Mark Sengelmann

From: Scott <Scott@bennettengineering.net>
Sent: Monday, September 26, 2016 4:17 PM
To: Mark Sengelmann; Will
Cc: Patrick Cotter
Subject: RE: 415 Cumberland Ave Planning Board items

ROOF PLAN
A1.5

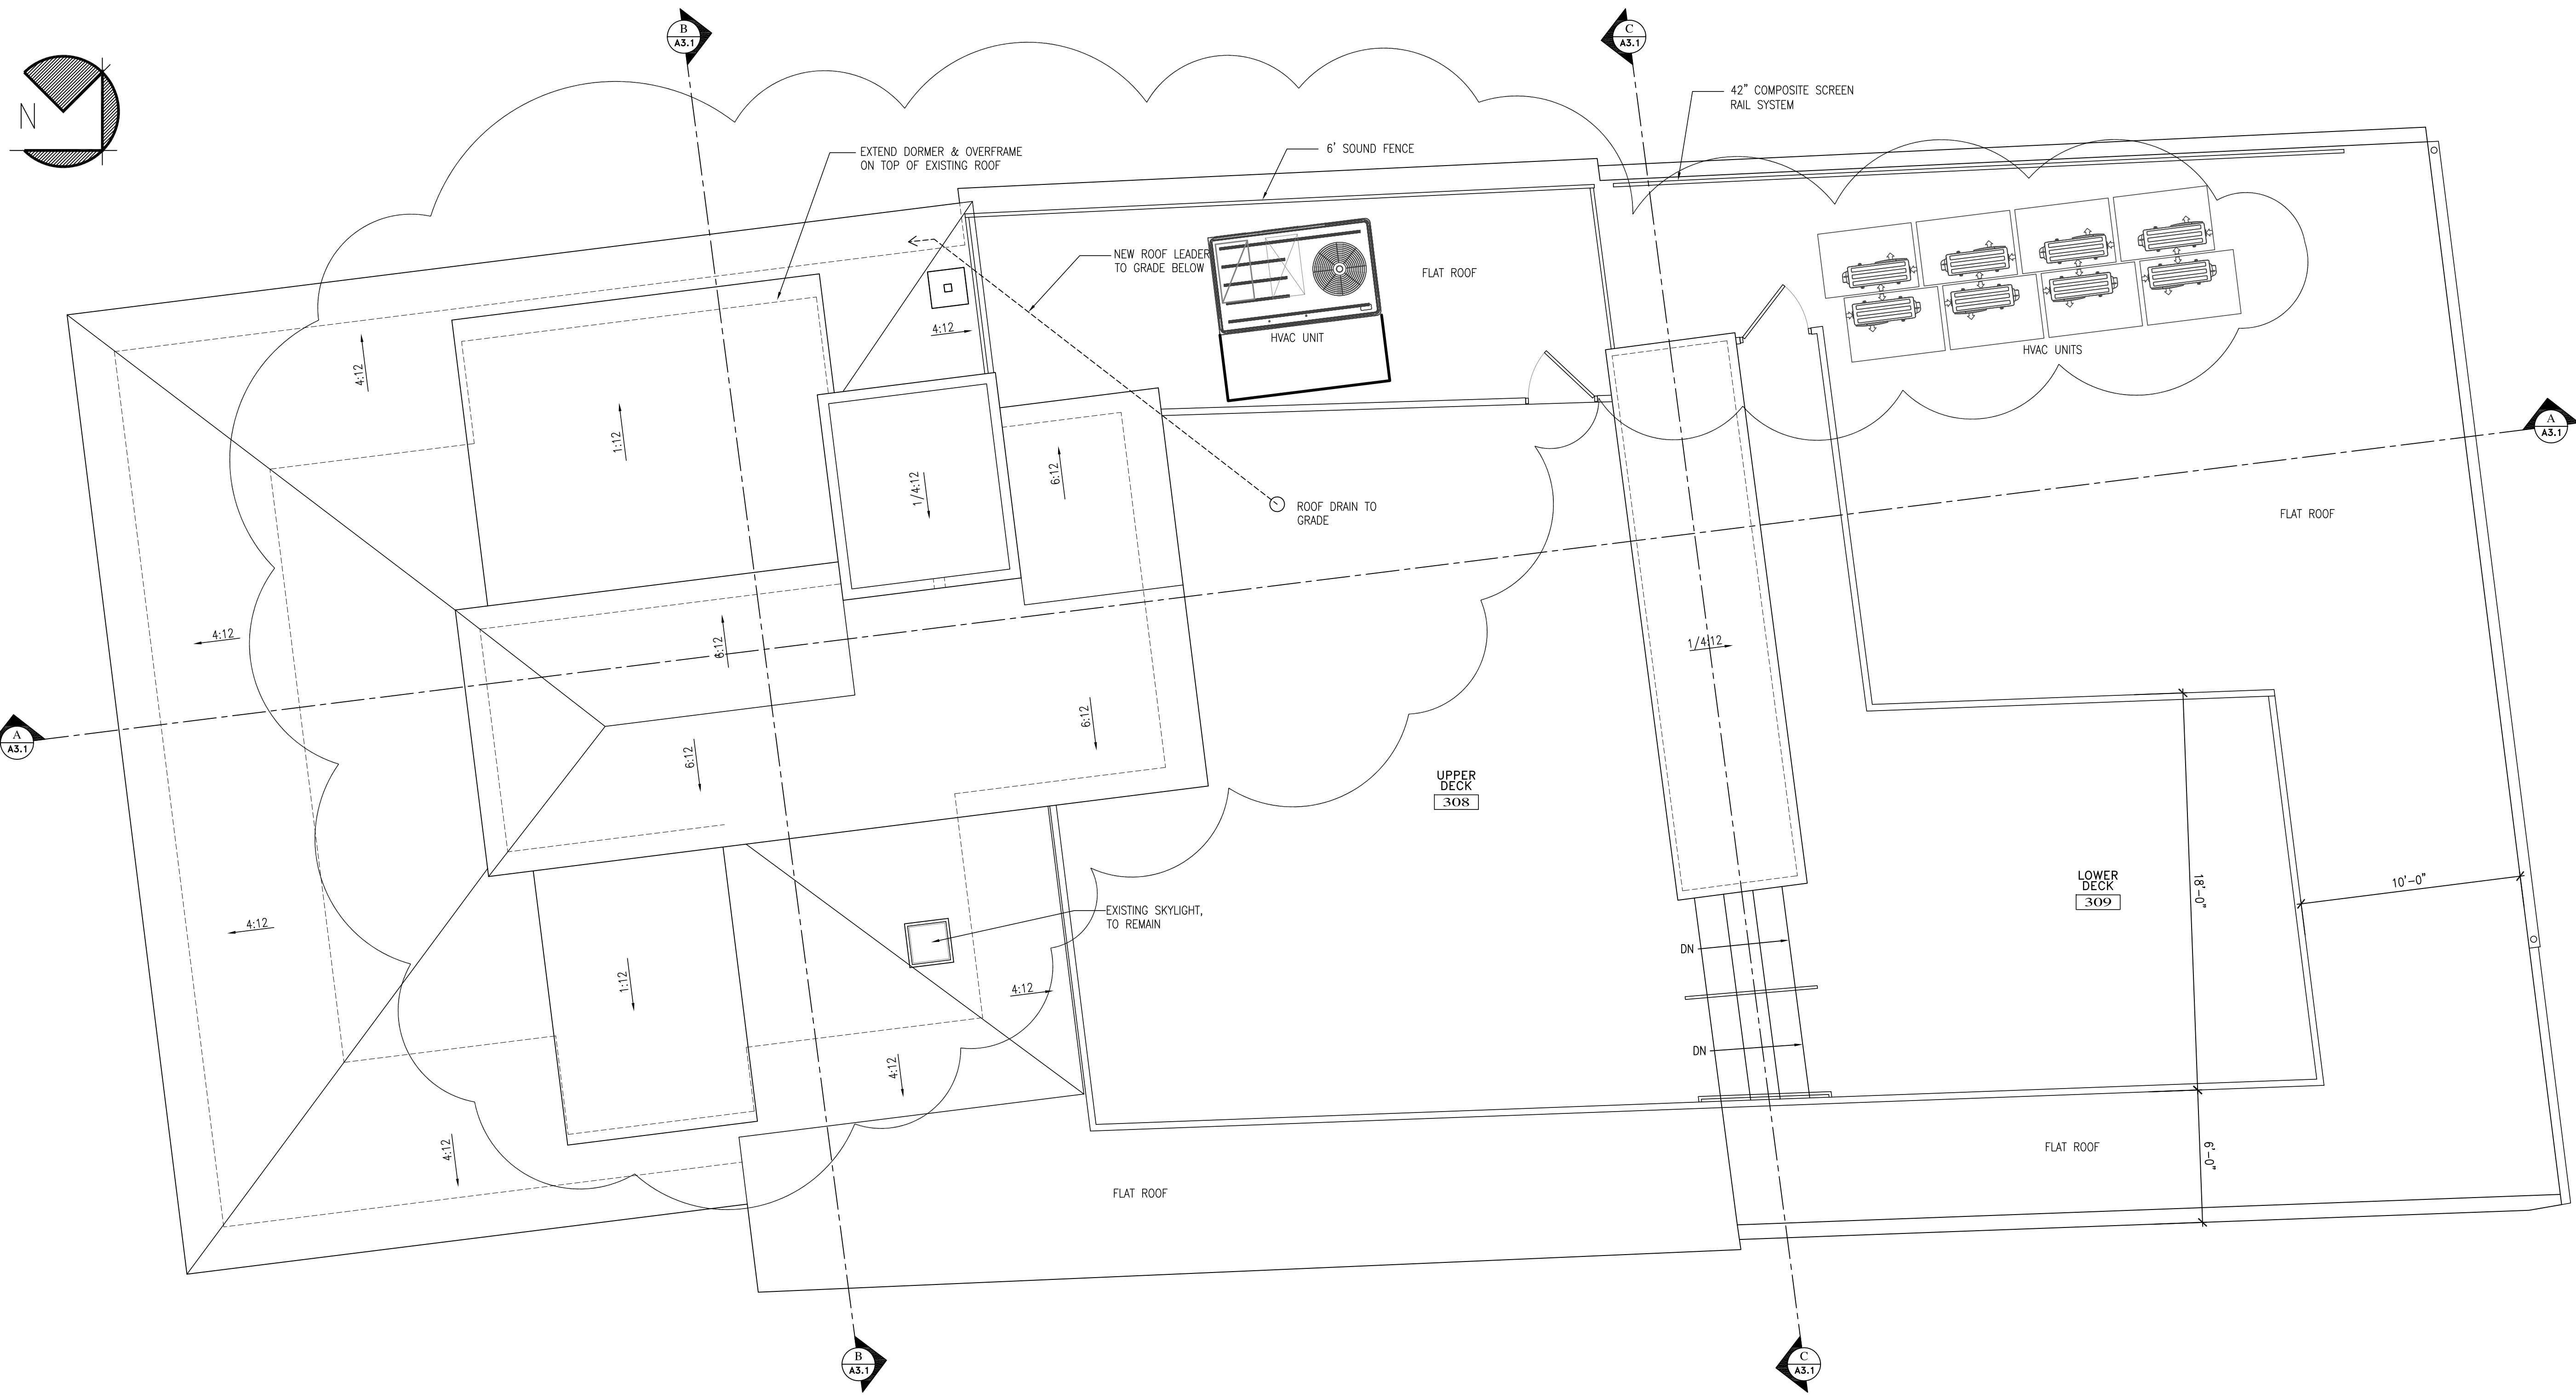
Planning Board is tomorrow night. Can you get me documentation on the 2 types of HVAC max sound output today? Also can you make the attached lighting updates ASAP?

The packaged rooftop unit (RTU-1) has an ARI listed sound rating of 82dBa. We are specifying factory furnished Low Sound Power Level Options including EBM Papst Quiet Condenser Fans Modifications, EC Modulating Condenser Fan Motor with Head Pressure Controls and Acoustical Compressor Enclosure that will reduce the sound rating to 55dBA at the unit.

The multiple split system condensing units (CU-#) on the roof have ARI listed sound ratings that range from 53-58dBa. The ARI standard rating is measured at 3ft from the unit and reduces by 6dBa every time the distance doubles. The boundary line is approximately 6ft from the condensing units therefore the sound would be reduced to 47-52dBA.
